From: Amanda Scholes on behalf of Planning.Responses
Sent: 14 July 2017 10:57
To: Planning Scanning
Subject: FW: CHECAA Objection (2) to AW/155/17/PL - Brus Lodge, 28 Kingsway - 12-7-2017. FRONT WALL CONSTRUCTION PLAN REQUESTED.

From: Simon Davis
Sent: 14 July 2017 10:51
To: [REDACTED]
Subject: RE: CHECAA Objection (2) to AW/155/17/PL - Brus Lodge, 28 Kingsway - 12-7-2017. FRONT WALL CONSTRUCTION PLAN REQUESTED.

Existing + Proposed Street Elevation

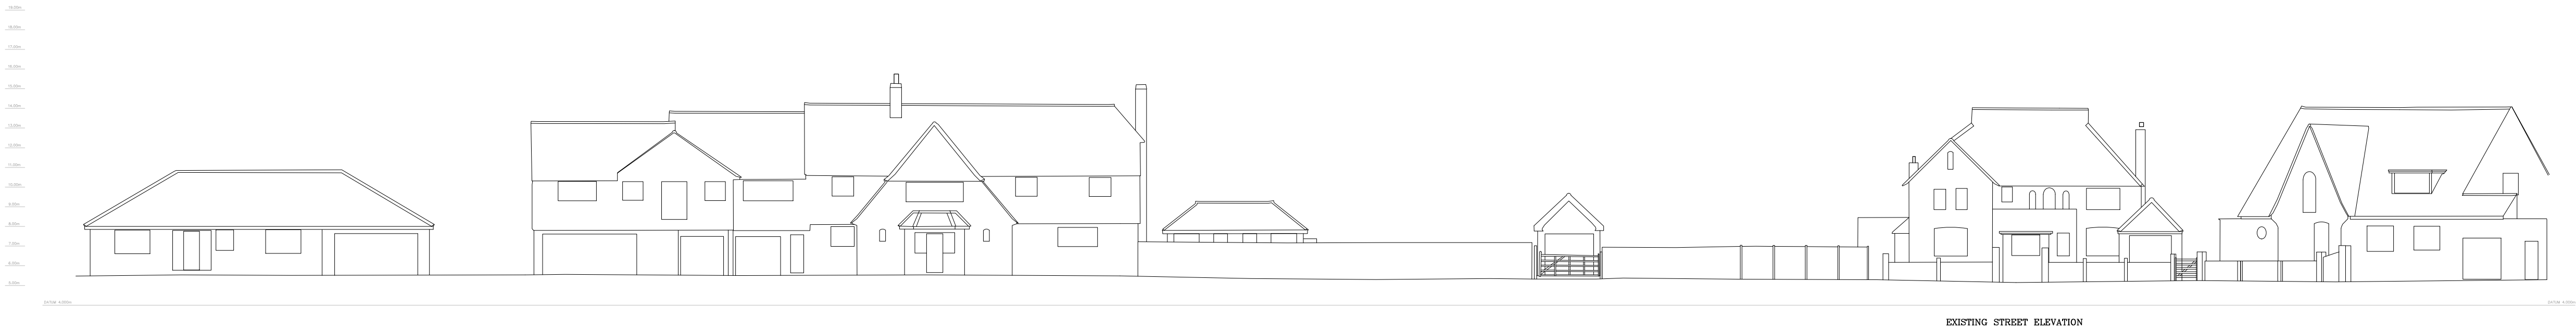
Uploading this to the website seems to have been overlooked and I have received no reply from you or any other. Can you please have a construction plan for the walls, gate piers and gates posted complete with measurements.

The design of the walls and piers is a very significant and material planning consideration in this sensitive part of the Conservation Area. Saying just 'brick' is inadequate!

We need to know the dimensions of the footings for the walls and piers and their accurate position in order to study their juxtaposition to all trees and shrubs.

Thank you for this information but it is our view that, far from being what you describe as being '**...the proposed wall...**' in the street scene this is, as is described today by the Conservation/Design Officer, no more than '**...an indicative illustration...**'. **For Seaman to suggest that this is a scaled plan at 1:200 is ludicrous and certainly NOT the case – you are asking us to believe that those 5 houses, windows, roofs etc are drawn to scale is totally unrealistic and not the case!**

So, the detailed information of the wall – critically important for us to consider with a Consultant in connection with the harm it and its construction will cause to all the trees (including the one on the verge owned, with the verge, by the Estate Company and Residents and not Brus Lodge) is still requested, please.

Just because I have not replied to you, does not automatically imply that I have done nothing with your email. Indeed, yesterday, I forwarded your second email to our admin team for upload to the website. This process is not instantaneous but your email will appear there. I have appraised the applicant's agent of both the Conservation Officer comments and your emails and I have asked them to consider providing a more detailed drawing of the wall.
